**Re: Objection to MP08\_0244 MOD 1 Modification Request for Mixed Used Development at 23-37 Lindfield Avenue and 11 Havilah Lane, Lindfield**

2 LINDFIELD AVE ELEVATION
2001 SCALE1 : 250

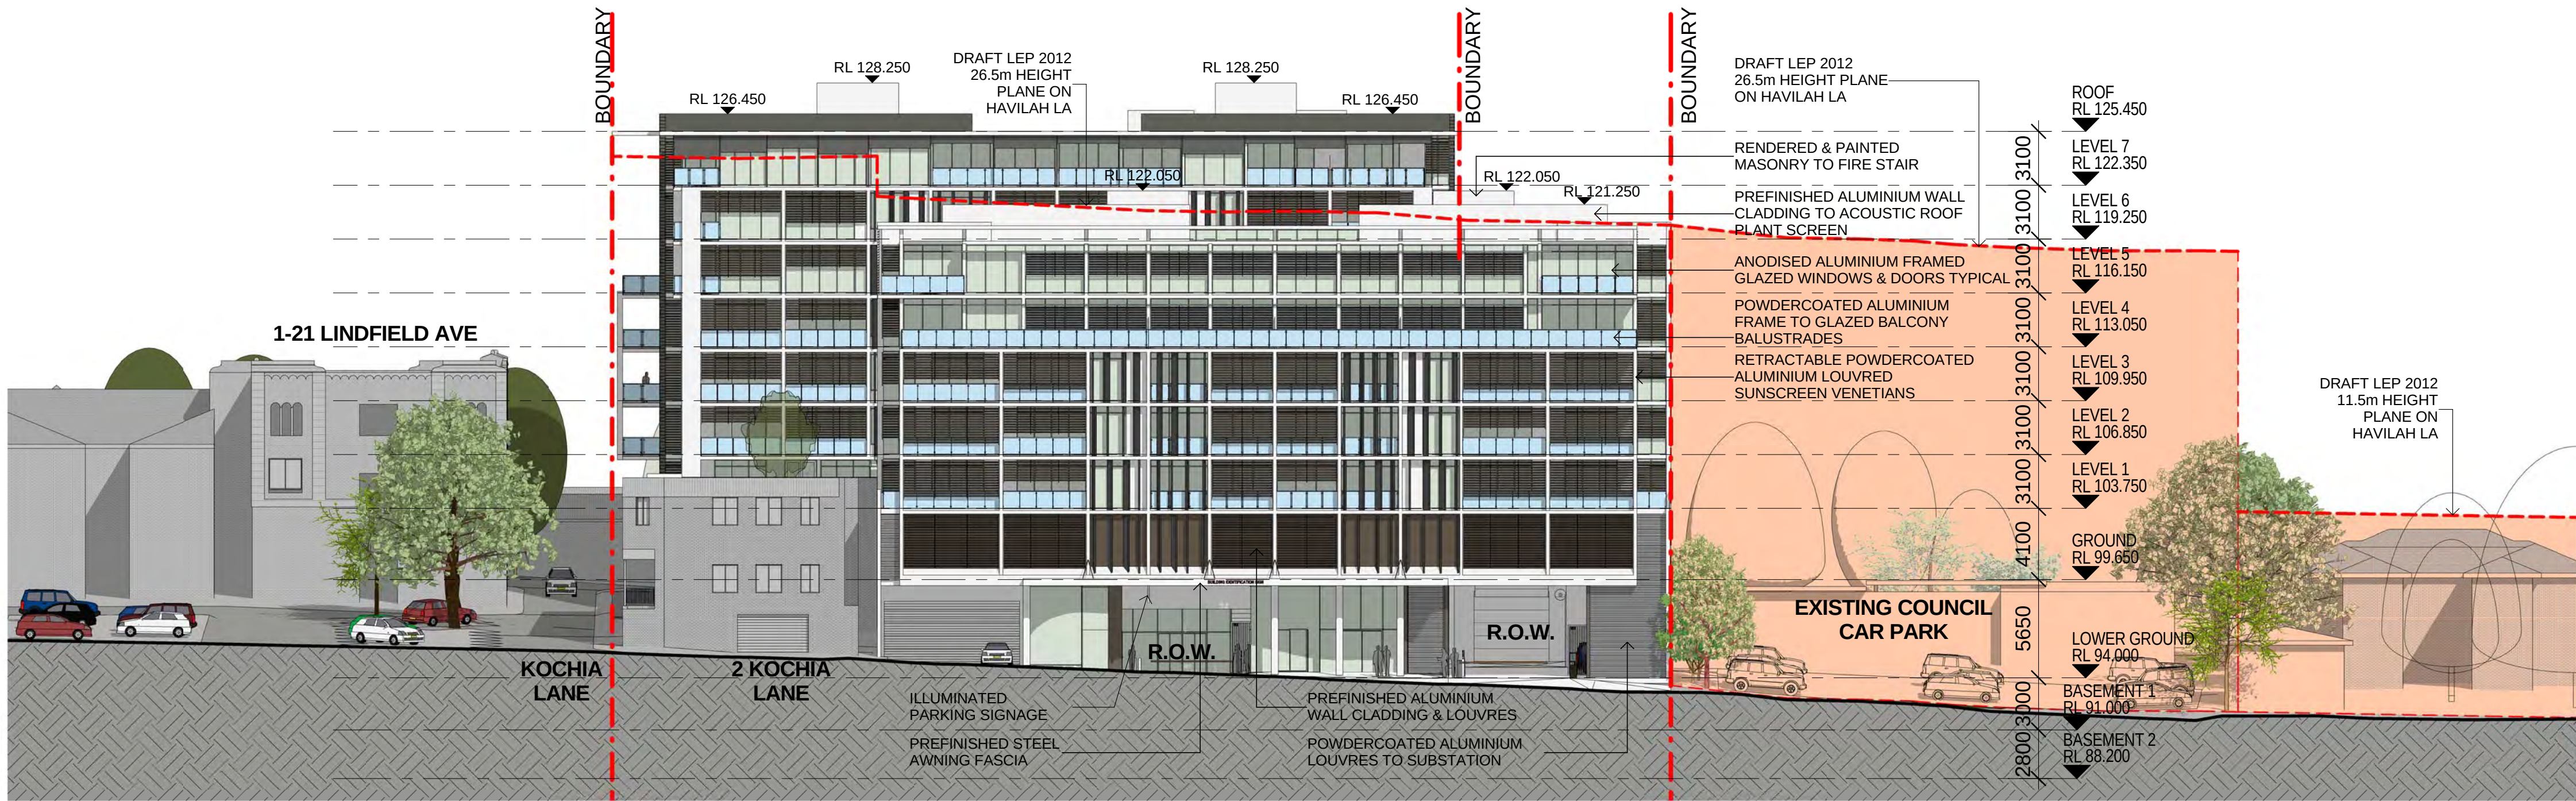
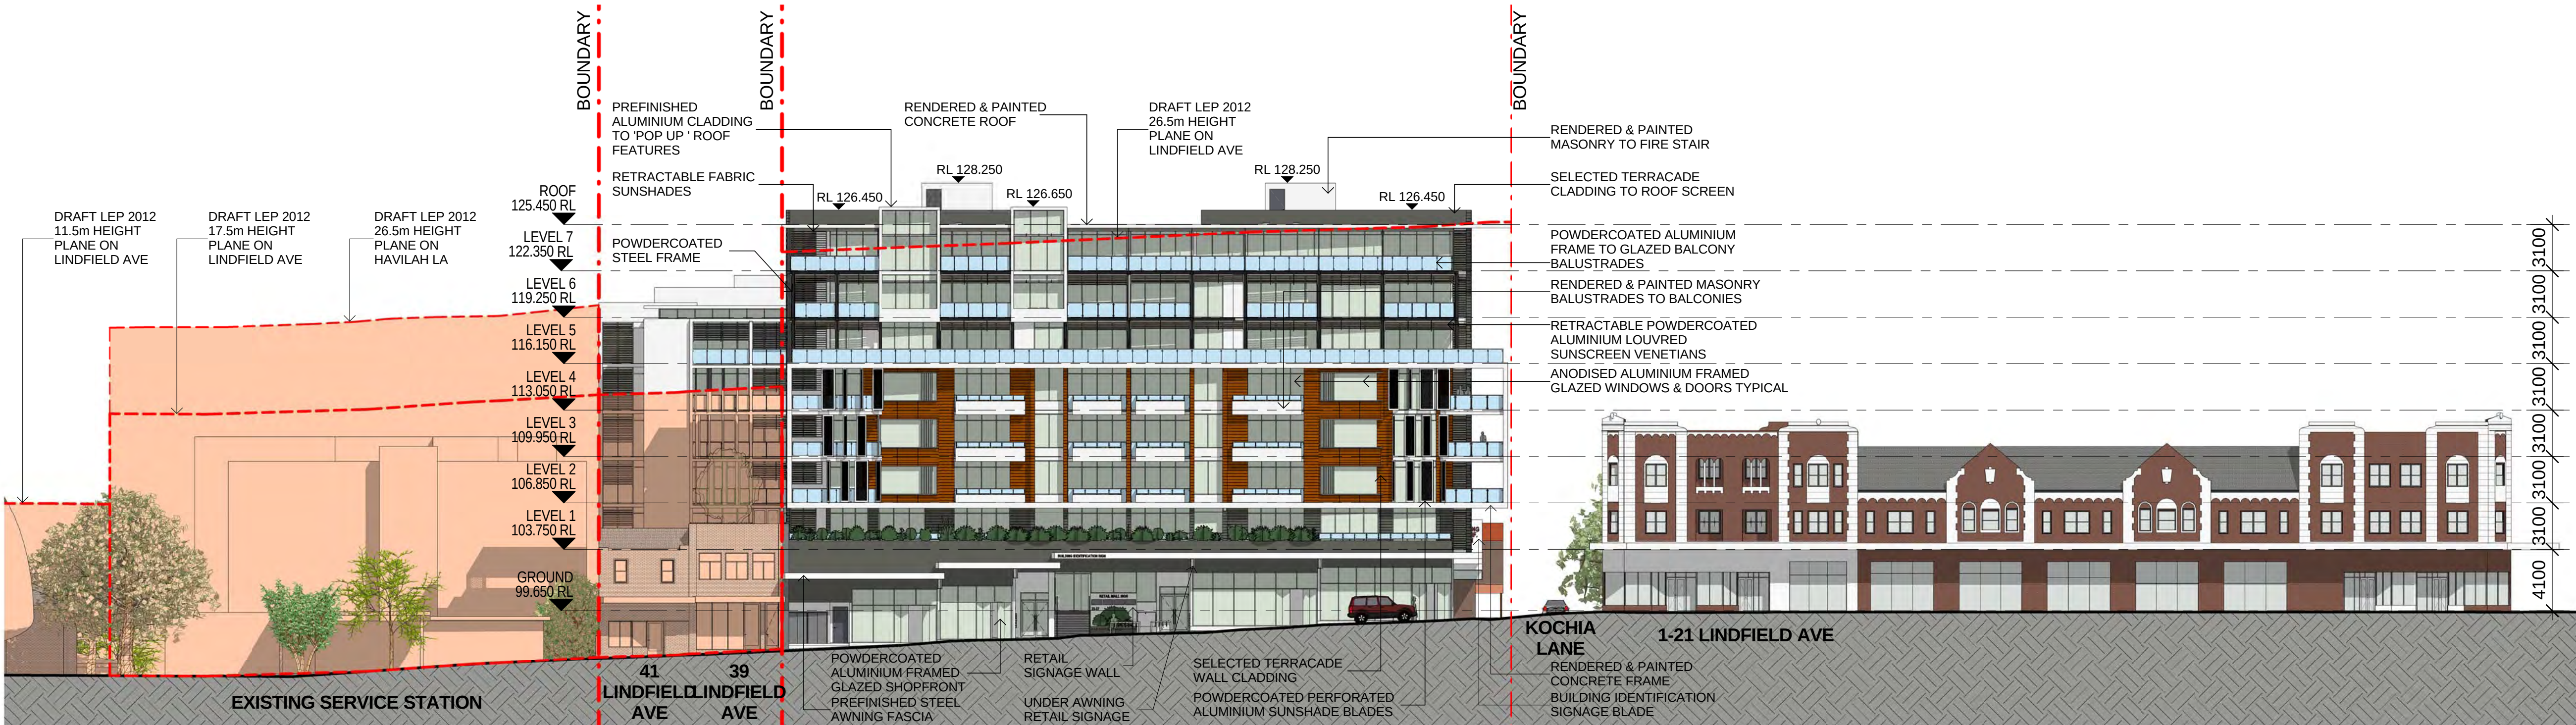
- The increase of an additional storey to both buildings: 8 storeys on Lindfield Avenue and 7 storeys on Havilah Lane creates excessive height and bulk and is out of character with the surrounding buildings, including the heritage listed adjacent building on Lindfield Avenue

1 SHADOW DIAGRAM - 21stDEC_9AM
5003 SCALE1 : 650

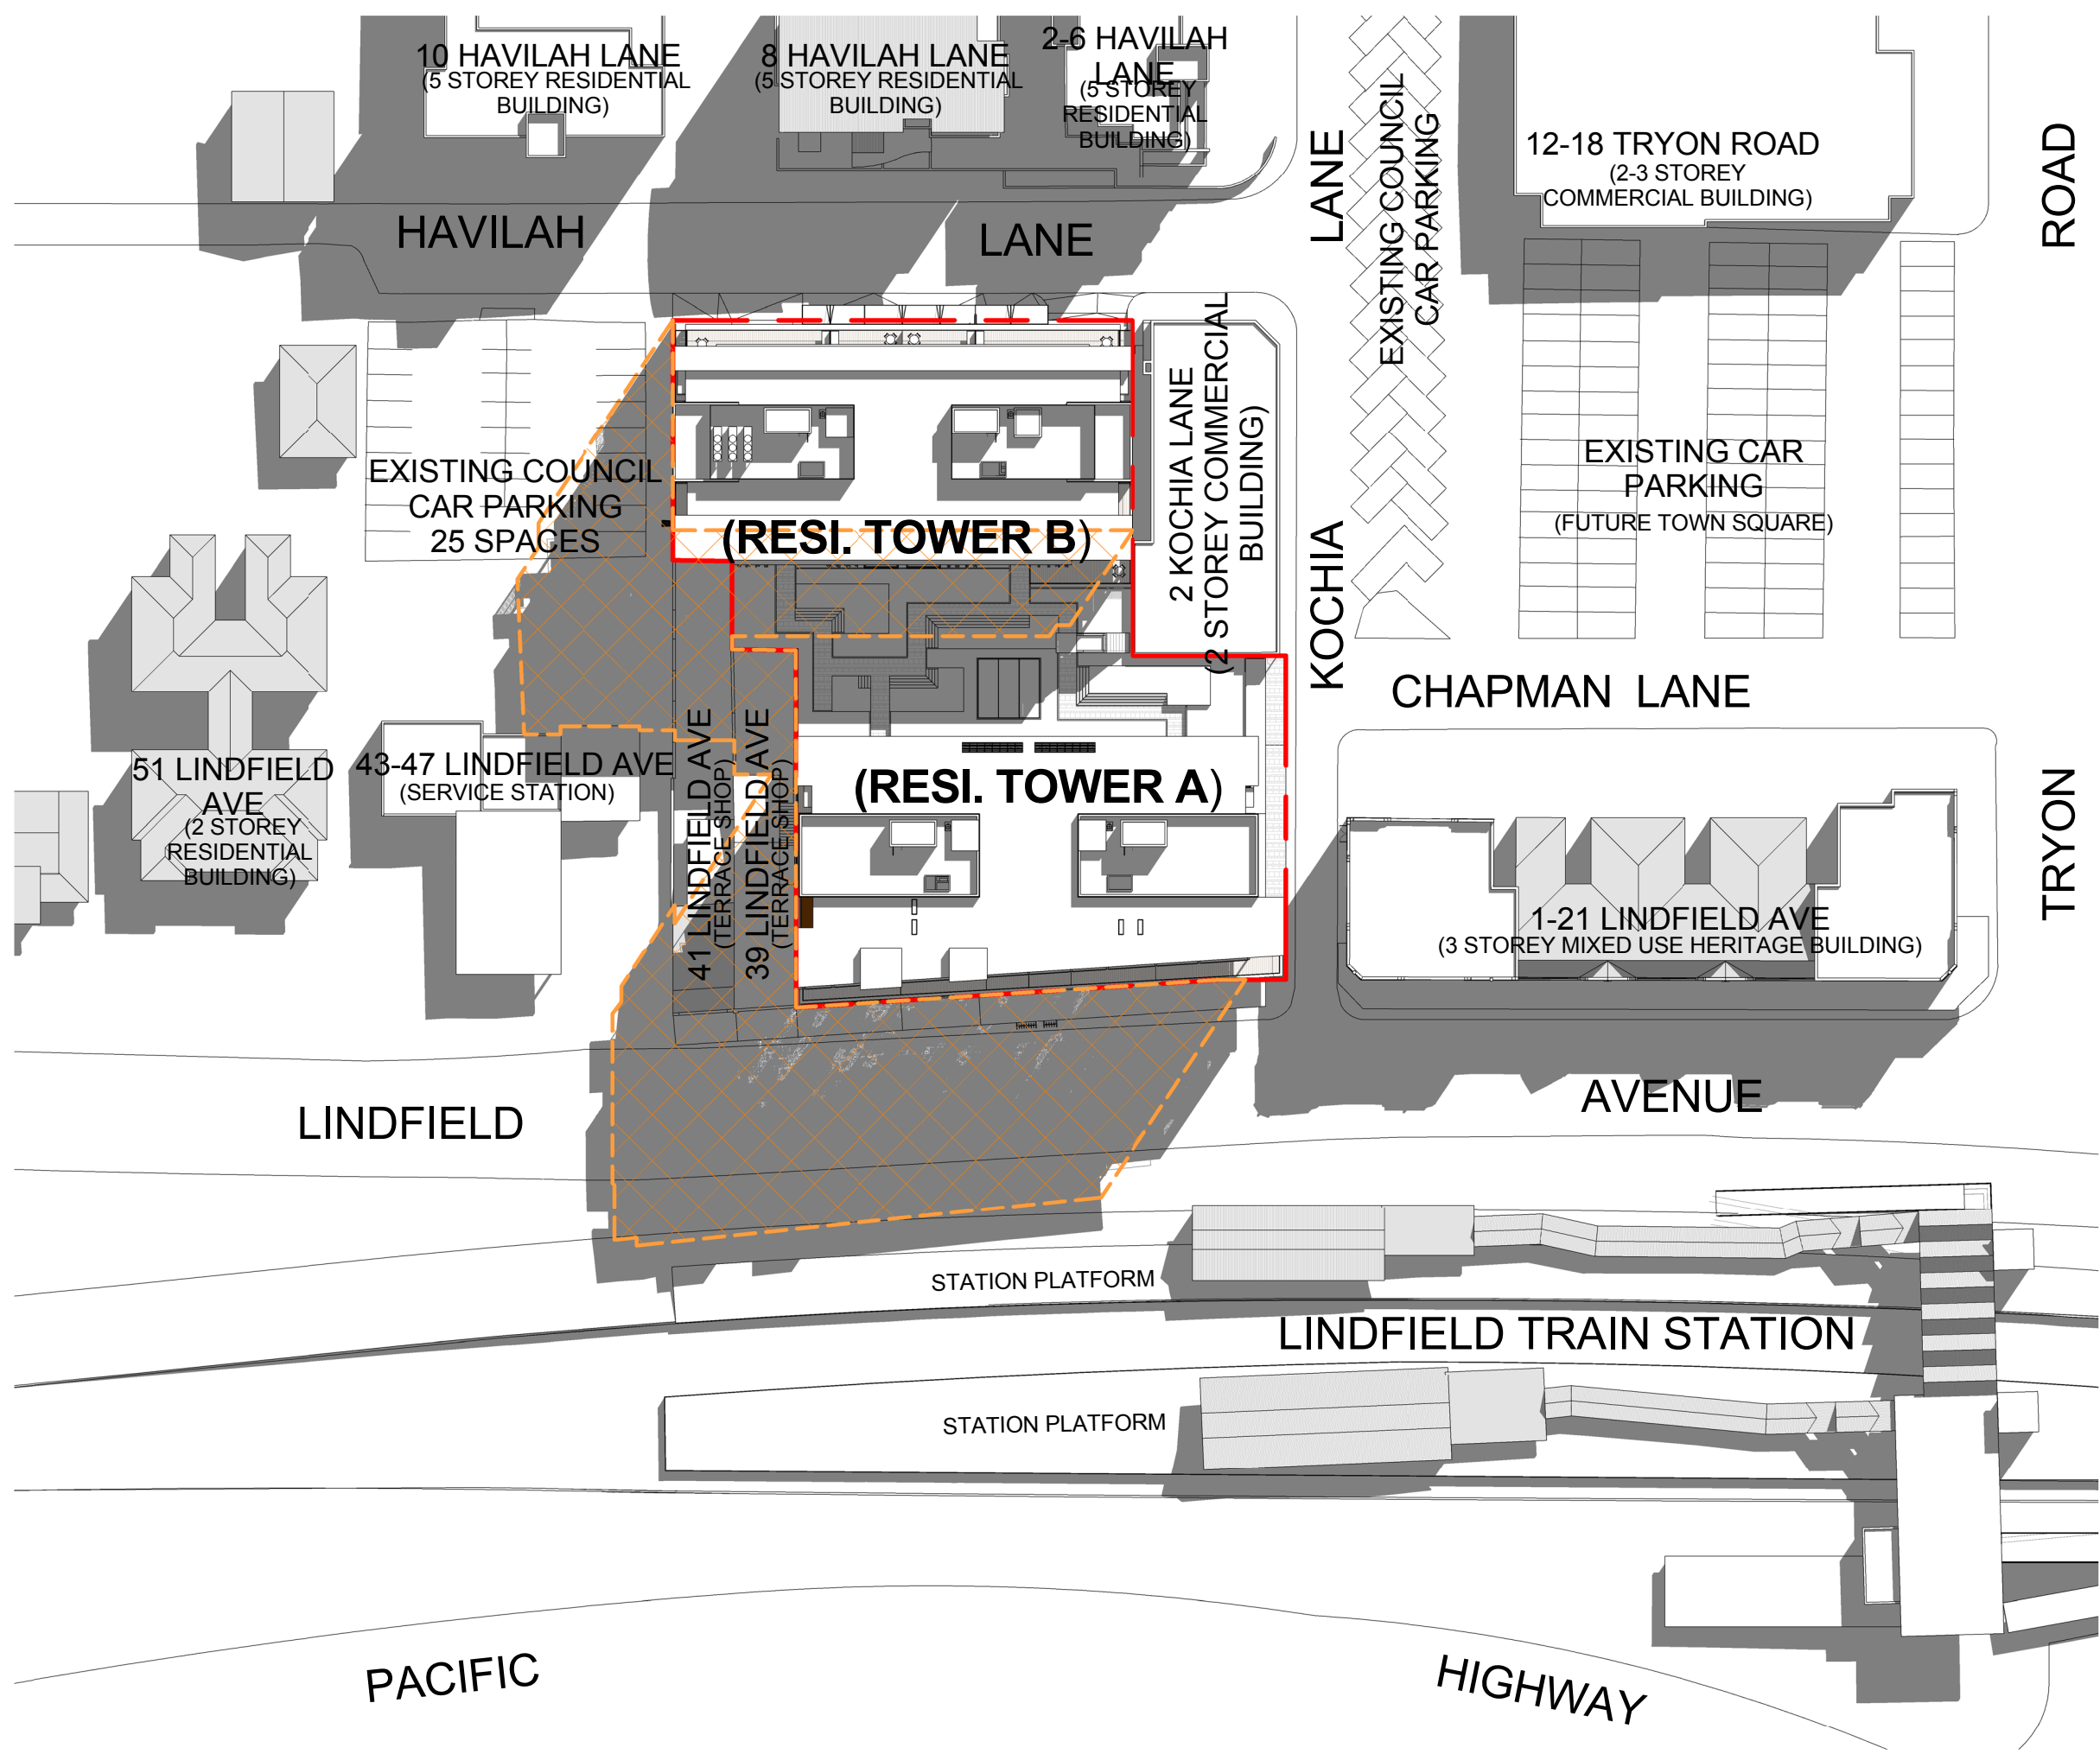
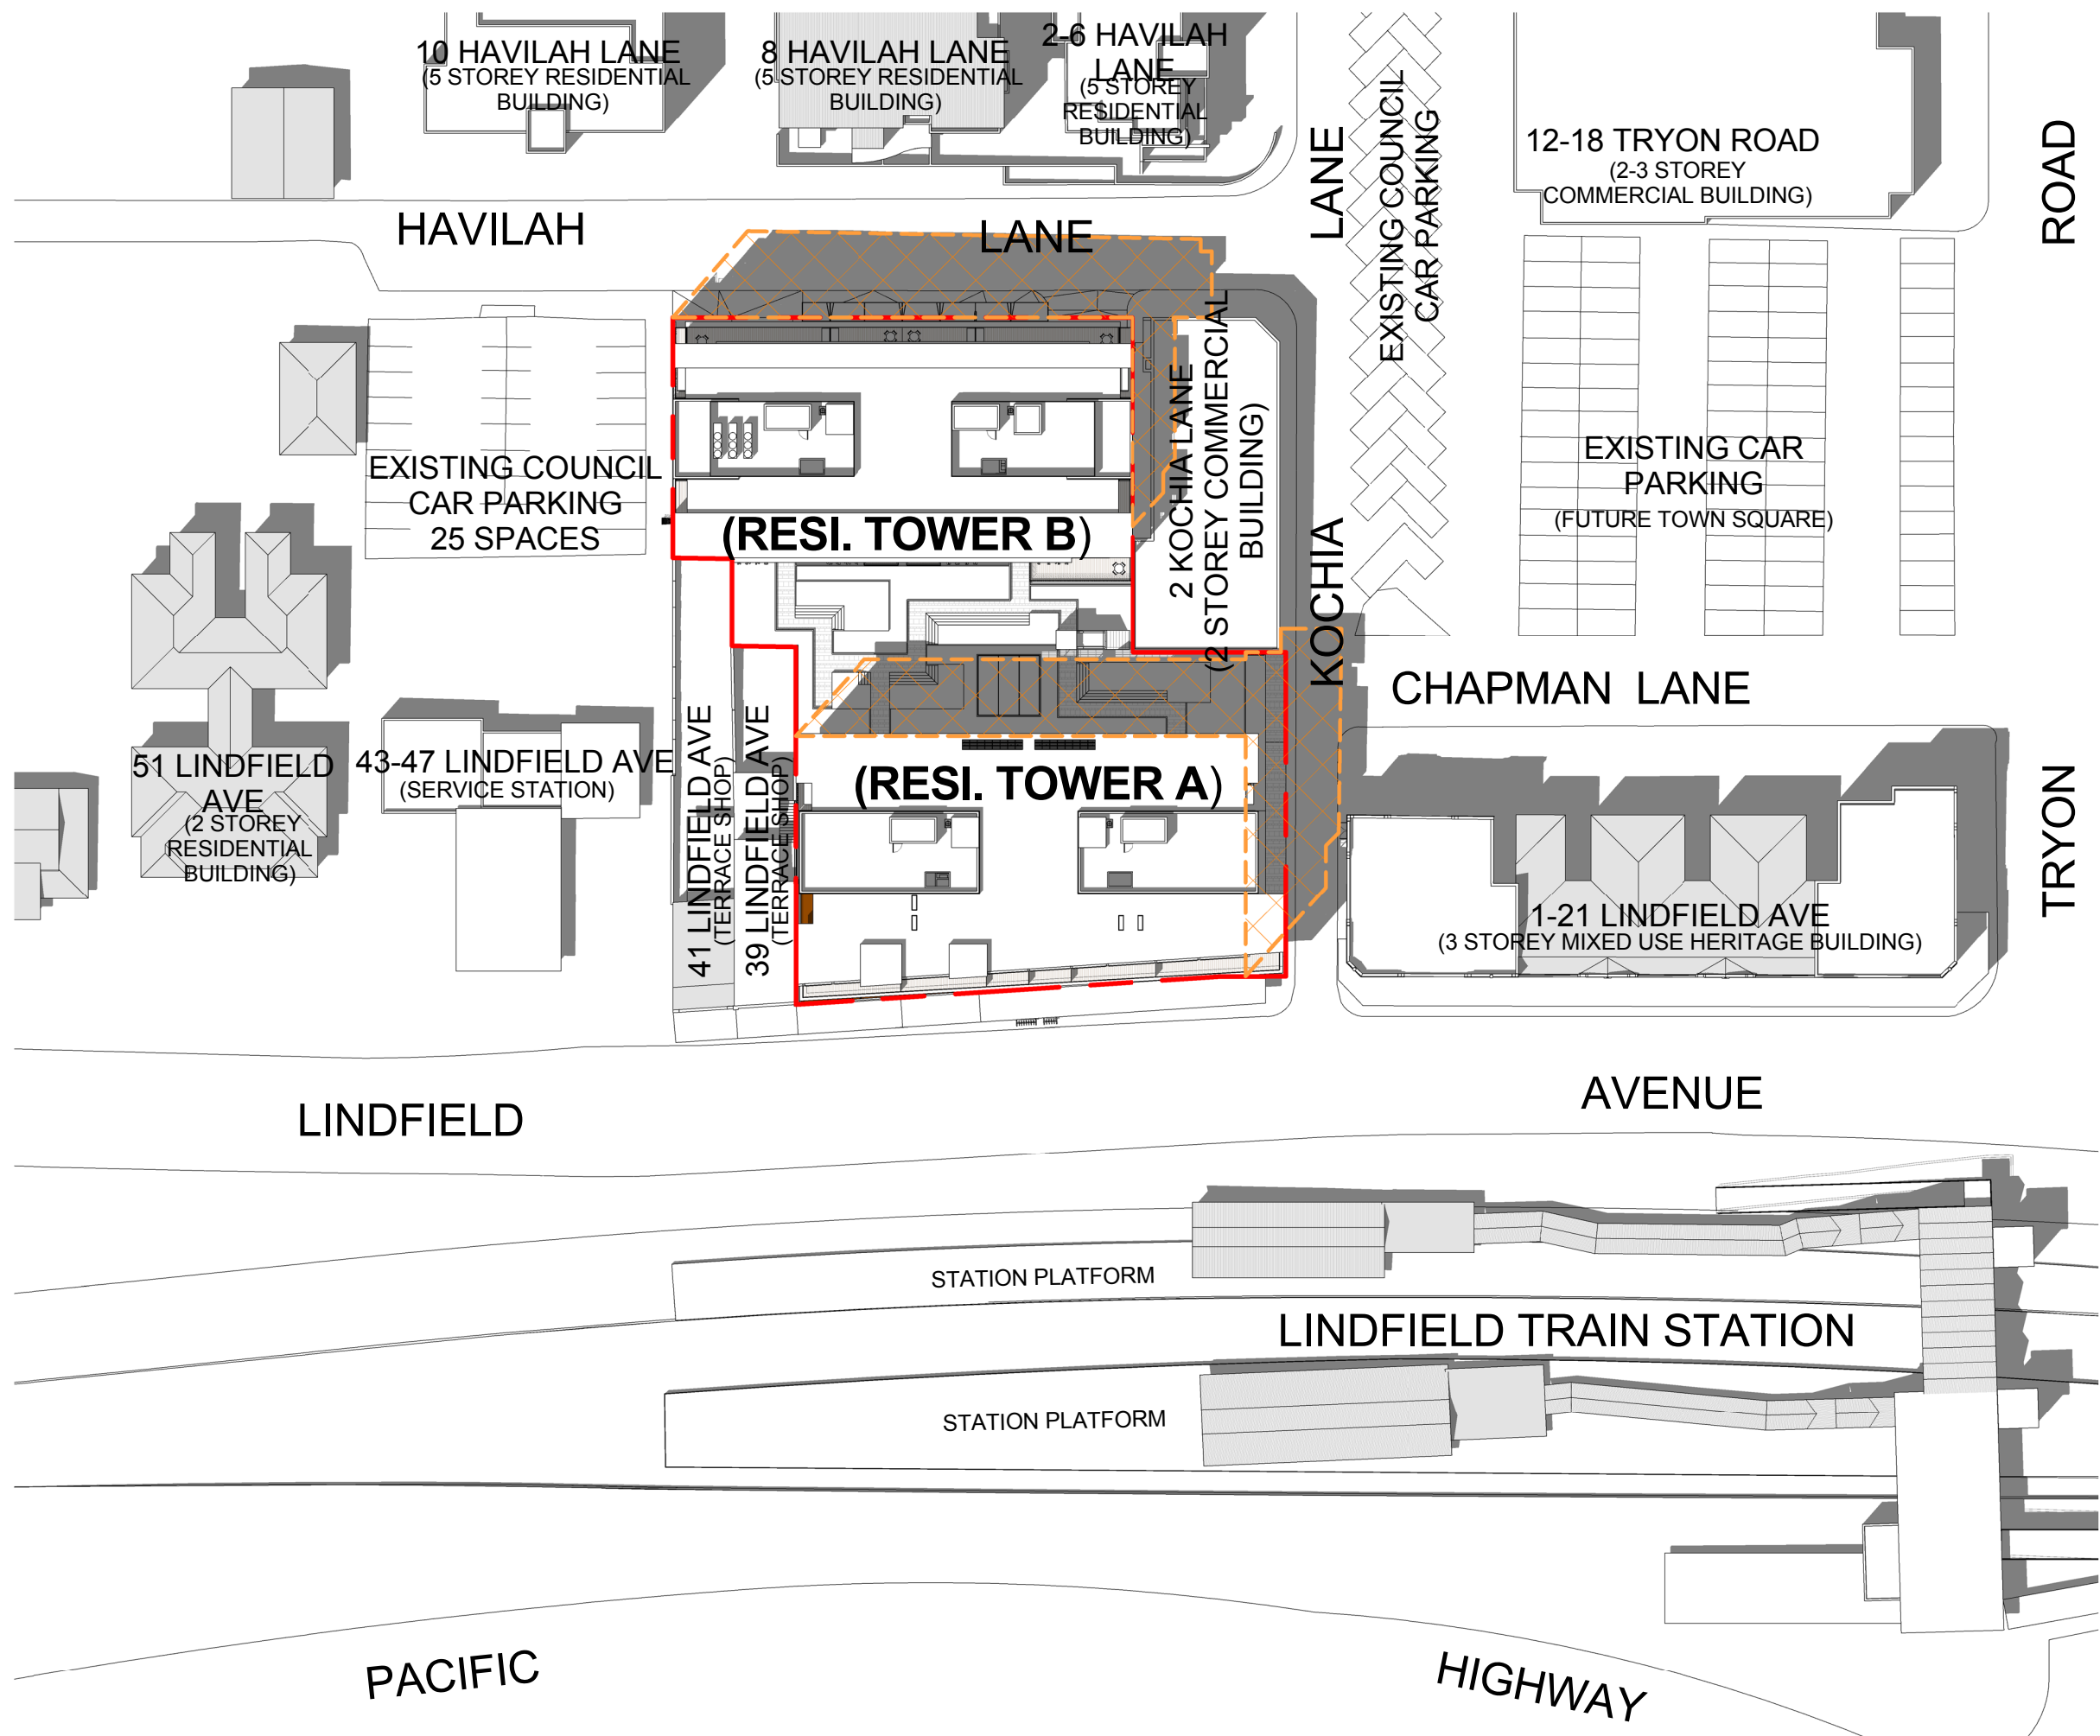
- The additional storeys create new adverse shadowing: a) for residents in the Havilah Lane apartments, particularly after 3pm b) for the popular outdoor café and central Lindfield hub area at 12 Tryon Road in afternoons, particularly in winter and c) for all commuters on the city bound Lindfield rail platform, instead of 50% of the year as approved, it will now be in shadow in the mornings 75% of the year
